Memo To: Barbara Barhydt  
Jean Fraser  
From: David Margolis-Pineo  
Re: Review Comments for the Neighborhood Center – 1342 Congress St (2015-058)

The Department of Public Services has the following comments.

C-2B

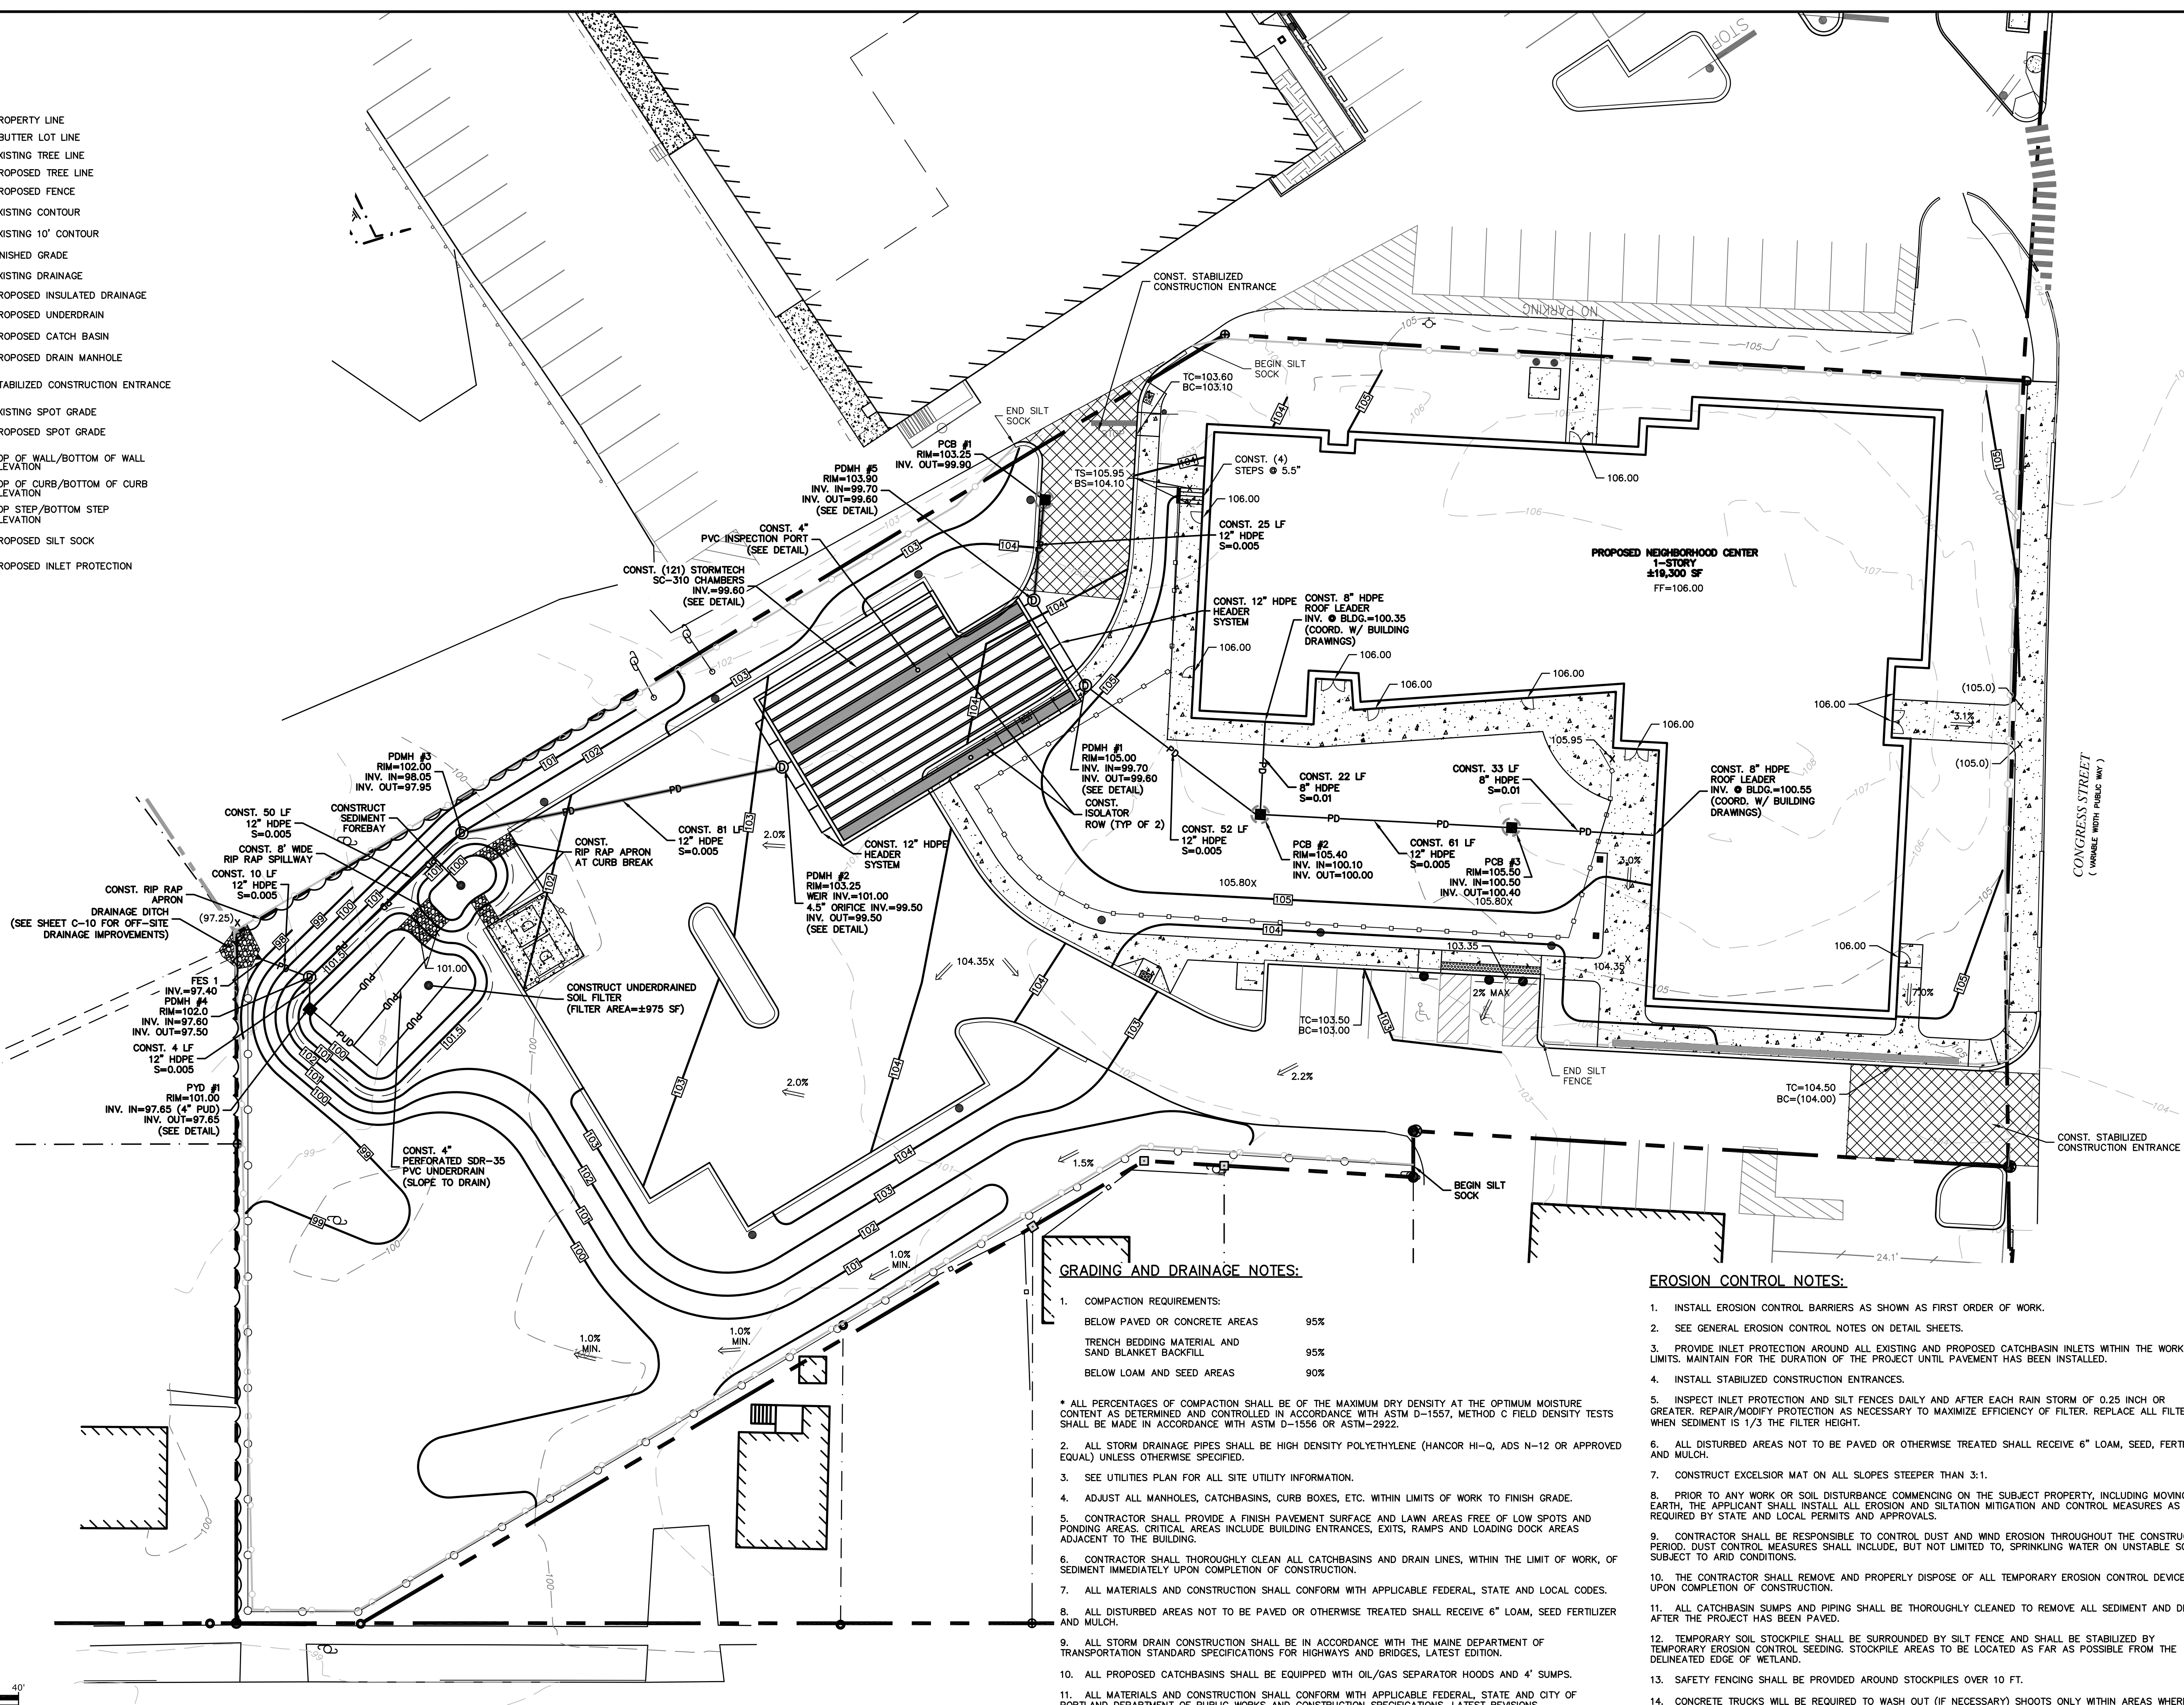
5. Please modify note 12 on sheet C-2B to read, “All work shall conform to the City of Portland Technical Manual standards.”
6. The catchbasin outlet control device referred to as “The Snout” is an acceptable alternative to the Casco Trap.

7. Please show and construct the proposed concrete sidewalk within the street right of way with the back of the sidewalk against the property line. This will result in an approximate eight foot wide sidewalk along the applicant’s property. The City would like to discuss with the applicant, the possibility of completing the sidewalk to the West of the applicant’s property in concrete at the City’s expense.

1,000 GALLON GREASE TRAP
NOT TO SCALE

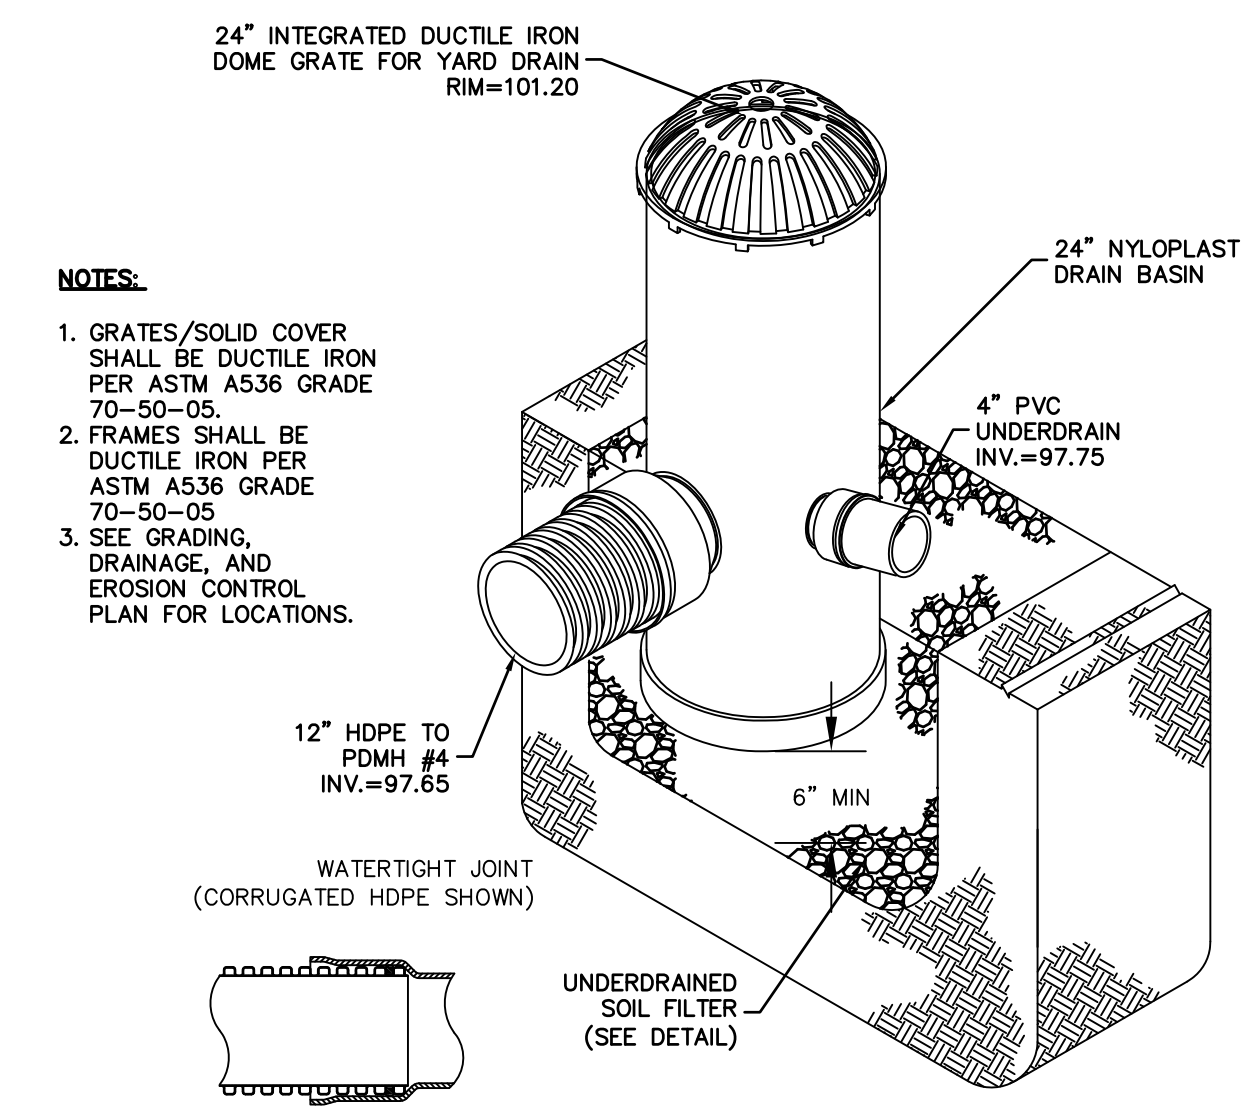
8. Only sanitary wasted is allowed to be discharged to the City’s sewer. No roof, site drainage or any other non-contaminated water is allowed.
9. Please provide a detail of the proposed grease trap. Please see Portland Technical Manual.
